**re: Geotechnical Responses to City Comments**  
**Proposed High-Rise Building**  
**1040 Somerset Street West - Ottawa**

**date:** March 28, 2022

**file:** PG2674-MEMO.14

A EAST ELEVATION
1:100

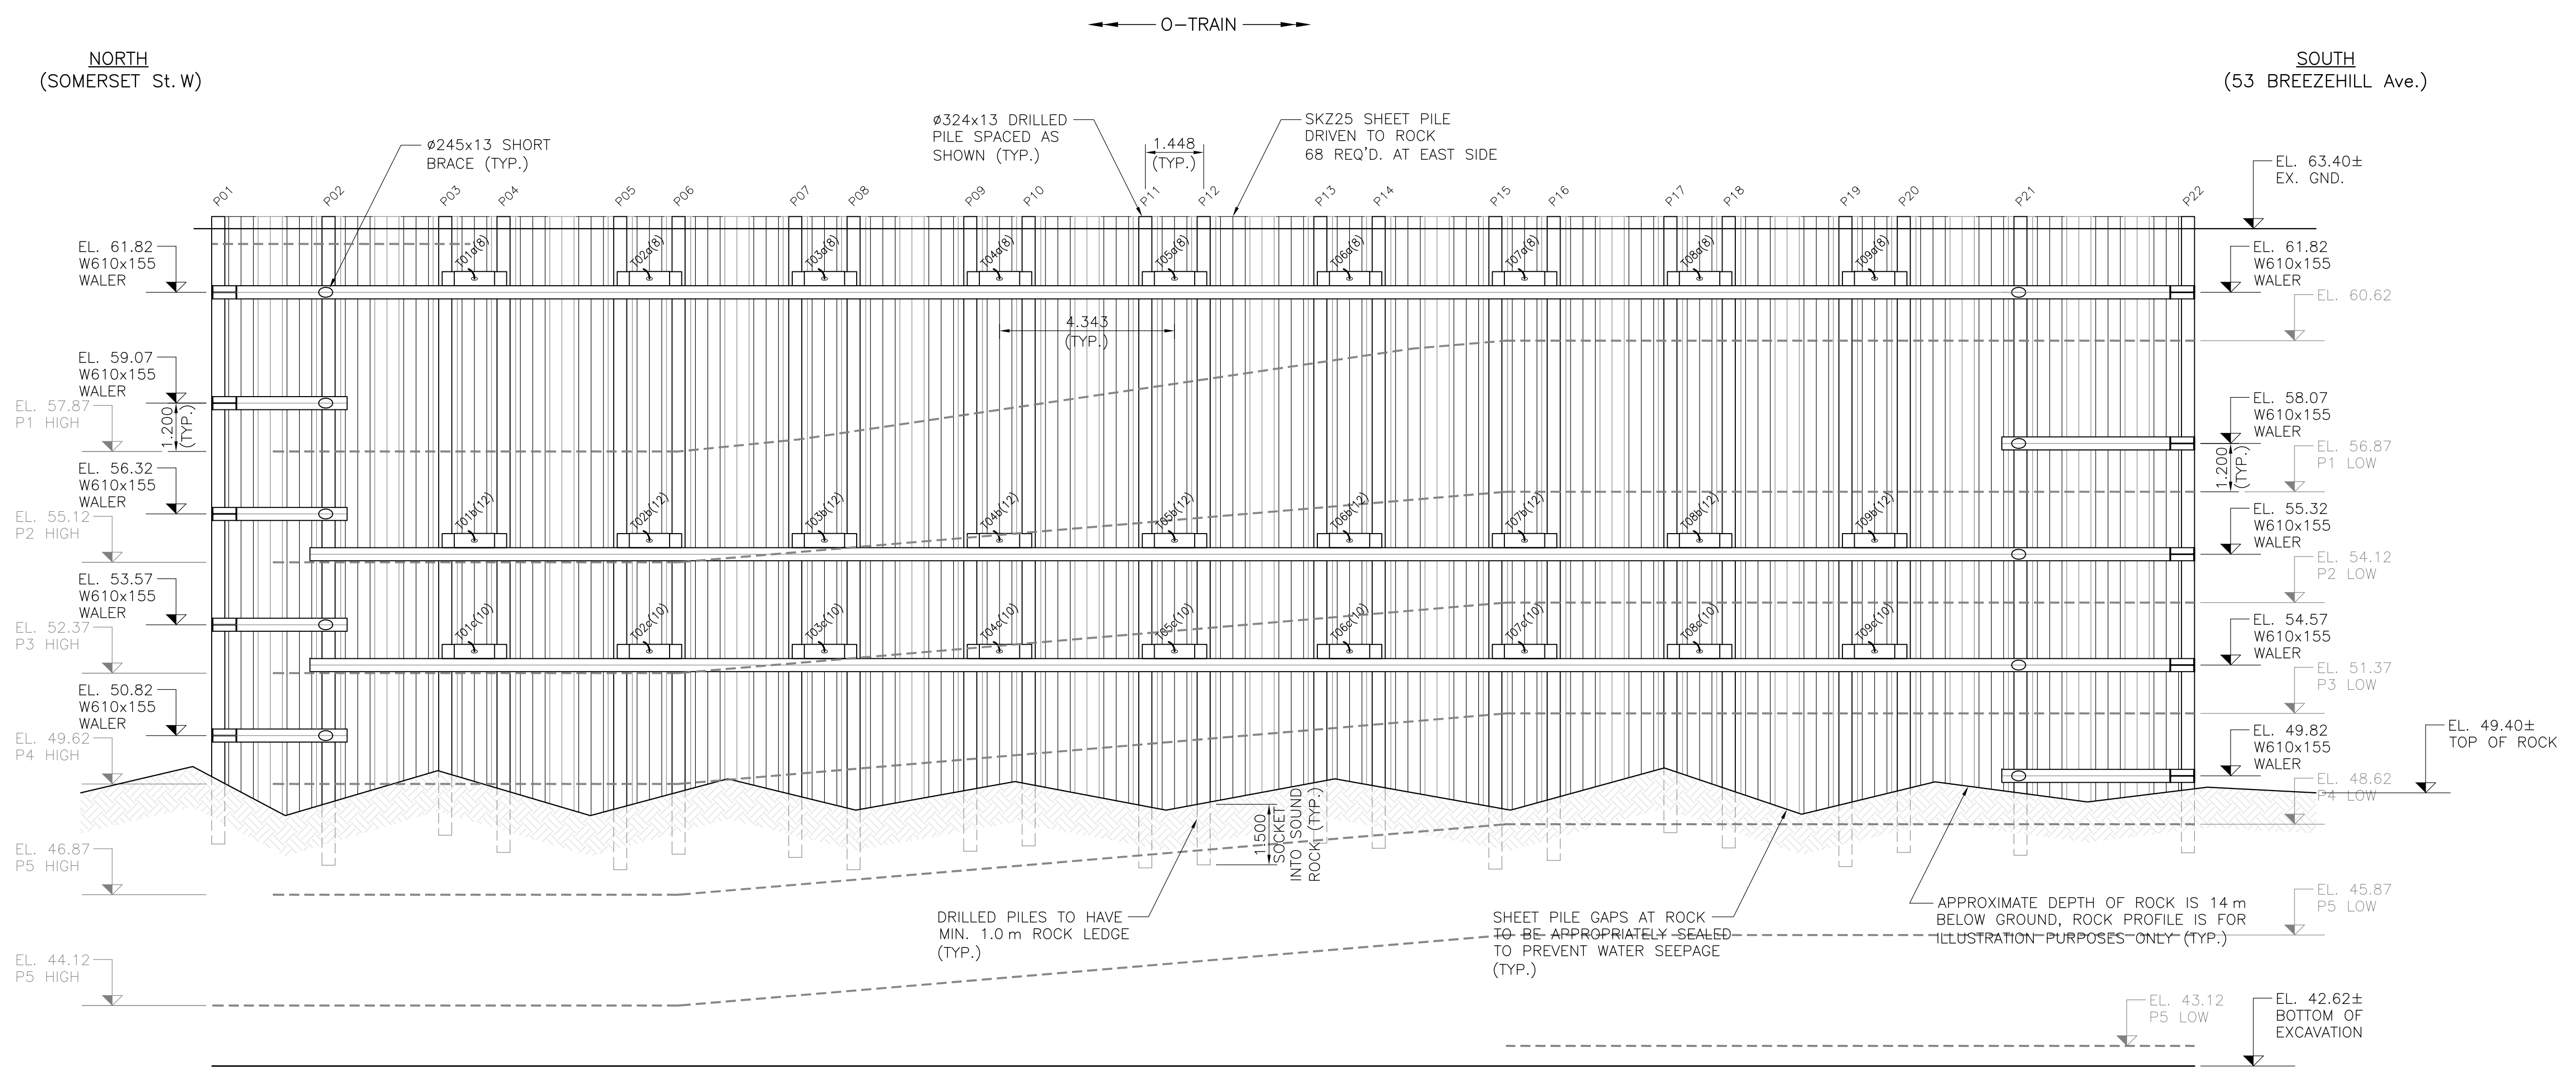
**Comment:** *What impact will short-term dewatering have on the proposed shoring system have on the existing bridge abutment and retaining wall structure.*

**Response:** Short-term dewatering of the underlying soils over a 12 month period for construction will not cause excessive settlement of the shallow footings supporting the retaining wall structure of the bridge overpass. Paterson has reviewed the soil conditions immediately below the existing retaining wall and the overall soil overburden profile as part of our geotechnical investigation.

Based on our observations, the soil below the retaining wall structure consists of a compact to dense, silty sand with gravel and cobbles, which was noted to be dry followed by a stiff to very stiff, silty clay deposit with low moisture levels. The abovenoted layers are underlain by a glacial till, consisting of a silty sand with clay, gravel, cobbles and boulders. The groundwater level was encountered within the glacial till layer, which is considered to be resistant to settlement due to short-term dewatering based on our observations and testing results.

It is understood that a temporary shoring system will be installed adjacent to the bridge abutment and retaining wall structure, which will allow dewatering of the supported soils. However, it is expected that the extent of dewatering will be limited due to the soil consistency. Also, the glacial till layer is not expected to undergo any significant settlement (ie.- less than 5 mm) due to the short-term dewatering. Therefore, the shallow footing supported retaining wall structure will not undergo excessive settlement (ie.- less than 5 mm) due to the short-term dewatering associated with the proposed excavation program for the subject site.
